SUBJECT: Engineering Review Comment  
Mountain View Electric Association Inc. (MVEA)

**Project Name: Barbarick Waste Transfer Station**

**Project Number: AL2310**

**Description:** Proposed development of a waste transfer station on approximately 5 acres located at 8812 Cliff Allen Point in Township 12S, Range 65W, Section 33.

SITE PLAN EXHIBIT

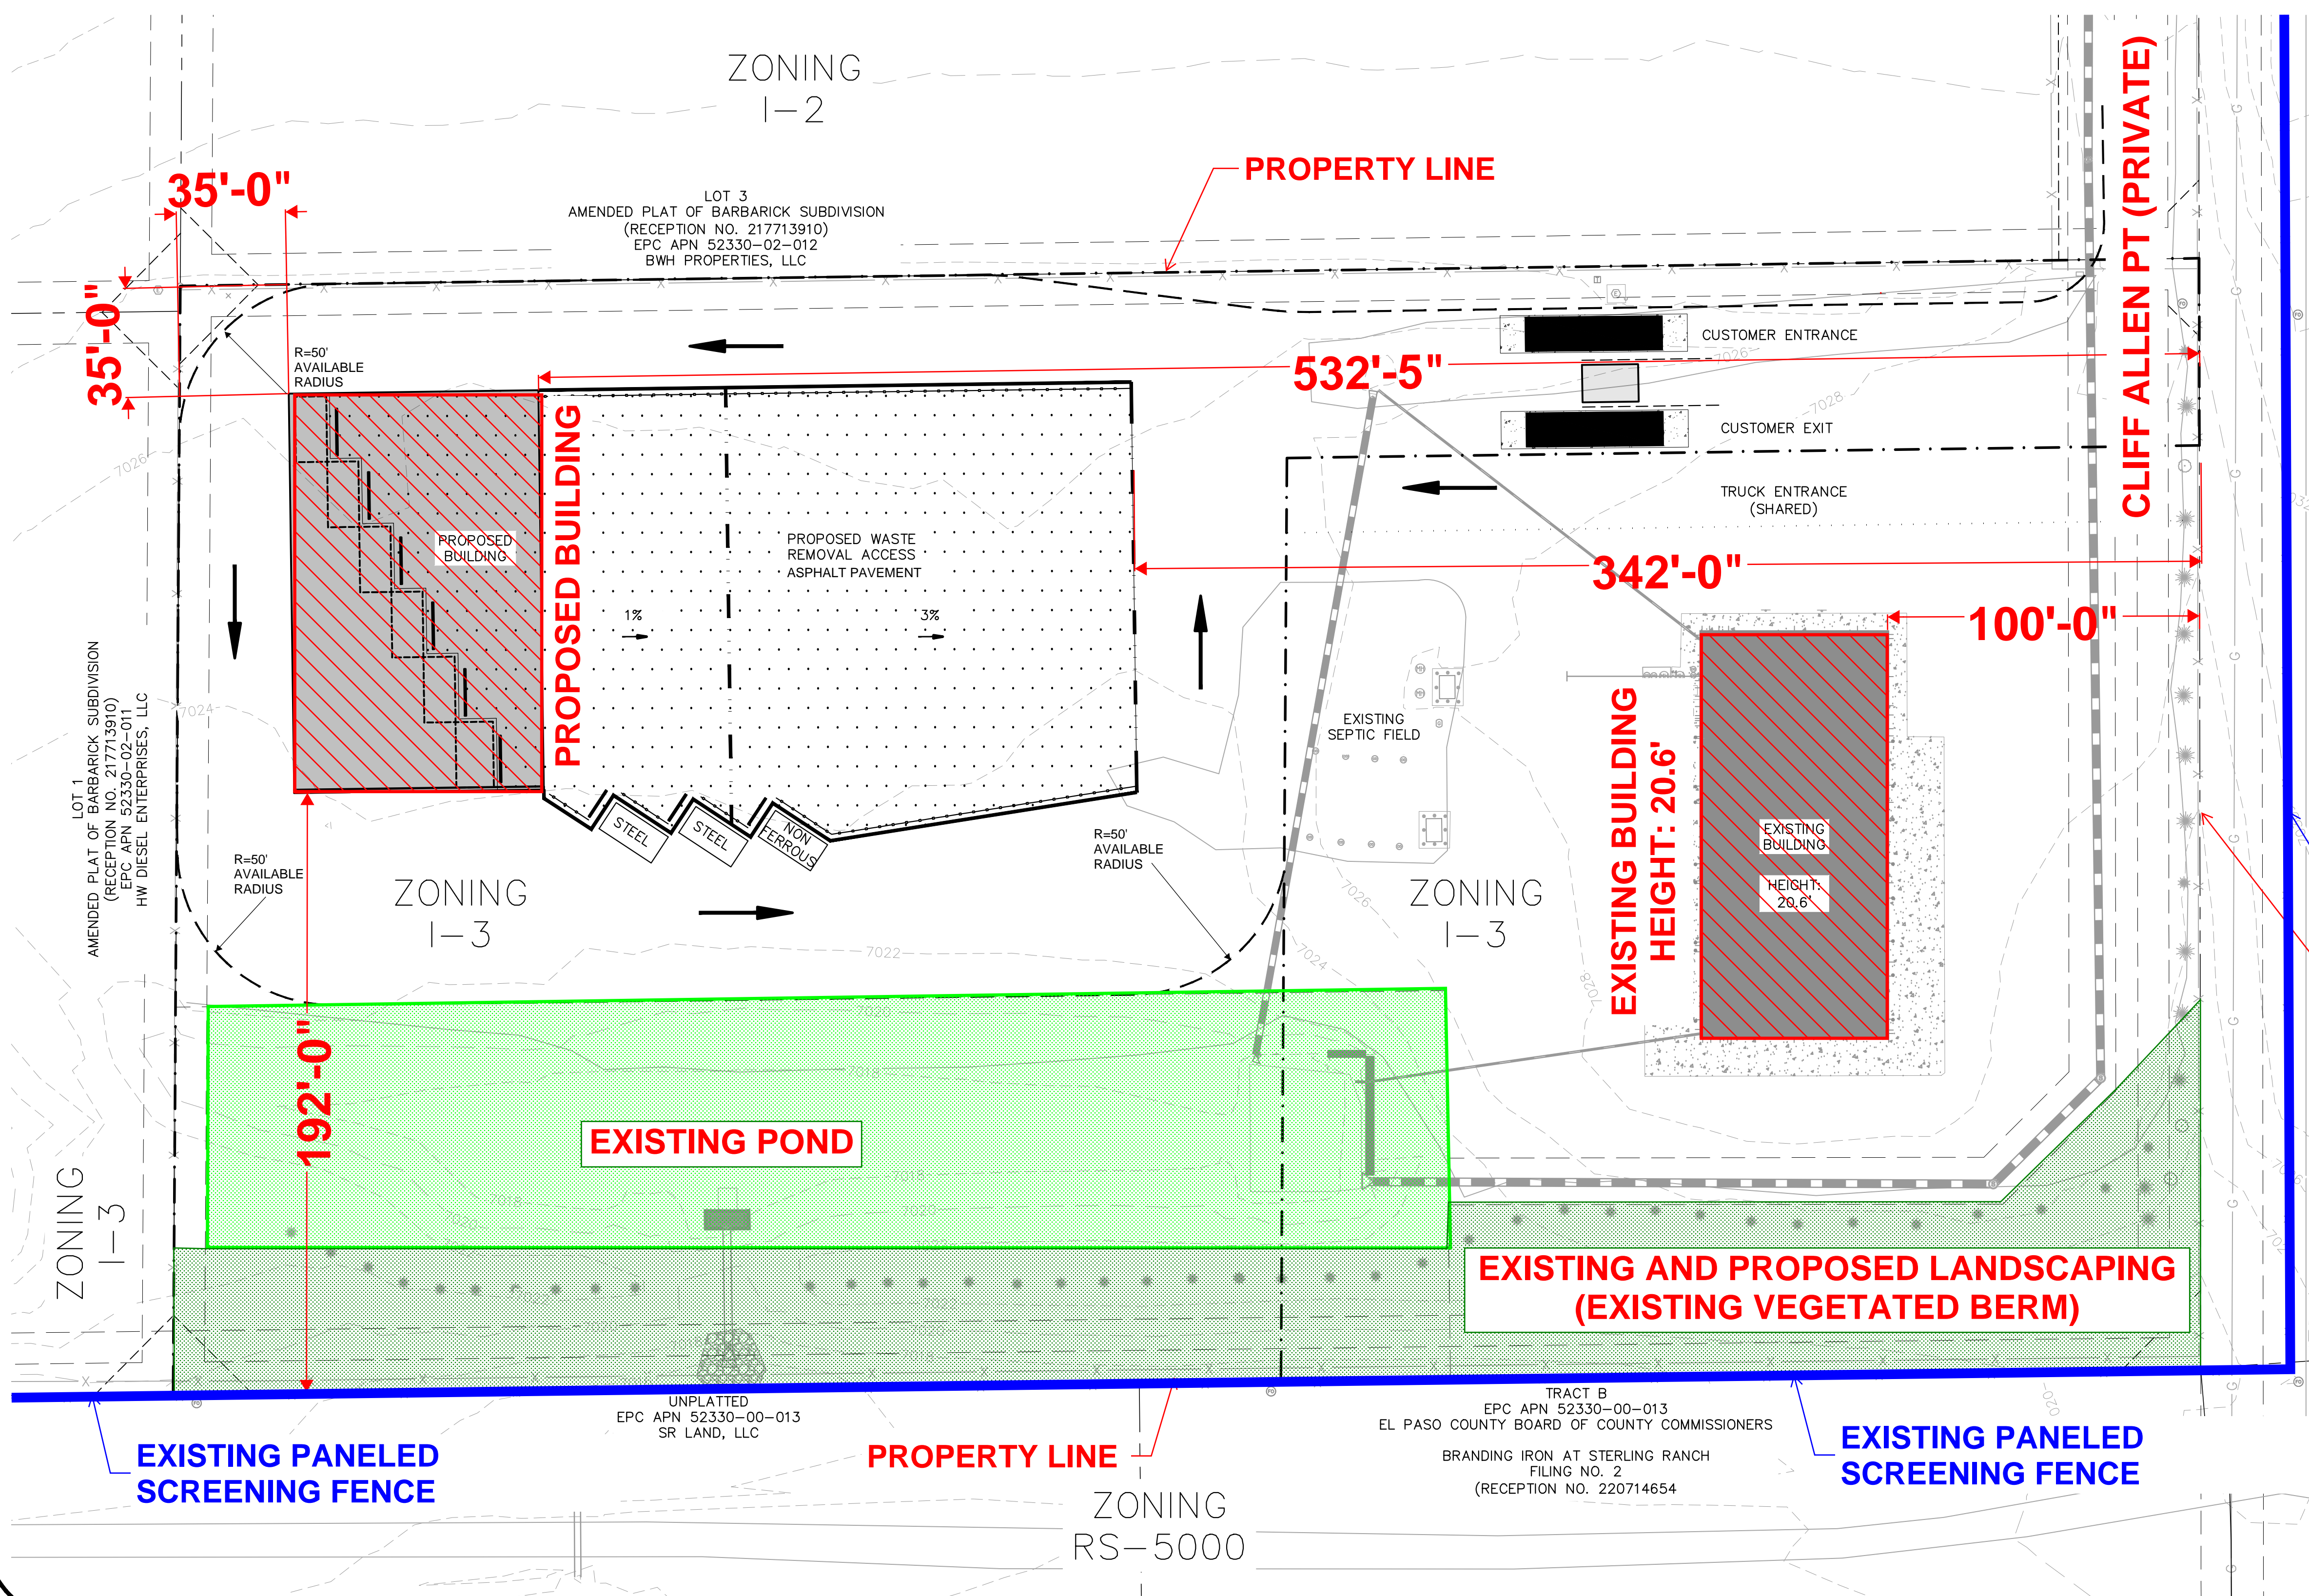
MVEA requests 10 feet clearance from the existing transformer near the entrance and exit area and will work with the developer on the design of the electric service and to acquire any needed utility easements. MVEA also requests the platting of MVEA's existing facilities with easements on the plat.

MVEA has existing facilities near and within this parcel of land. If there is any damage, removal or relocation of facilities it will be at the expense of the applicant.
